TfNSW Reference: SYD19/01350/64
DPHI's Reference: SSD-10448-MOD-6

**ASPECT INDUSTRIAL ESTATE MODIFICATION 6
788-882 MAMRE ROAD, KEMPS CREEK**

TfNSW has reviewed the submitted application and provides the following comments for Department's consideration:

Figure 11 Concept Proposal MOD 6 Layout

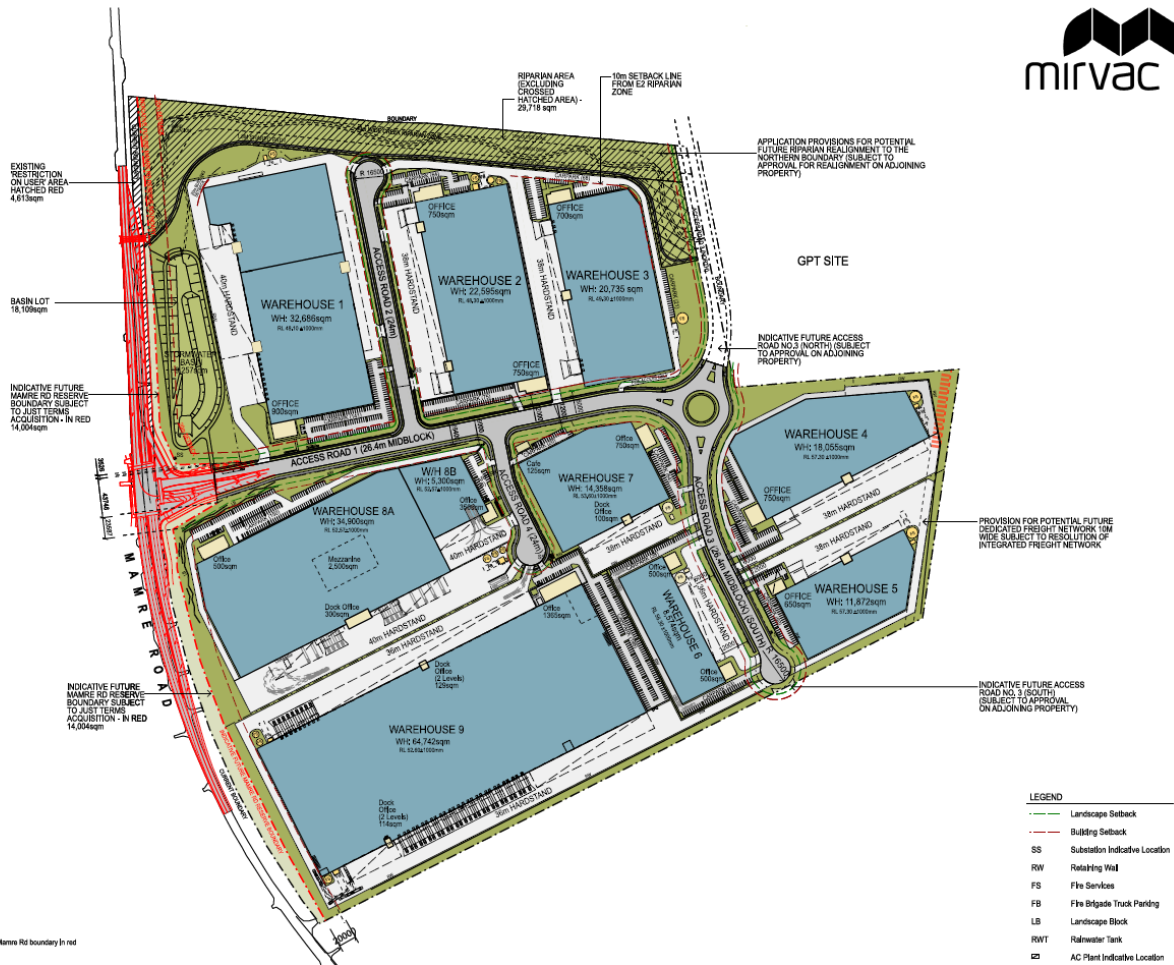
1. The proposed two car parks share single access off Access Road 4 and create conflict between vehicles accessing Car Park 1 and Car Park 2. The proposed light vehicle access needs to be modified to eliminate the conflict and improve the safety of road users.
2. The proposed light vehicle access is located too close to the intersection of Access Road 1 and Access Road 4. This access needs to be relocated further away from the intersection to ensure traffic efficiency of Access Road 1.
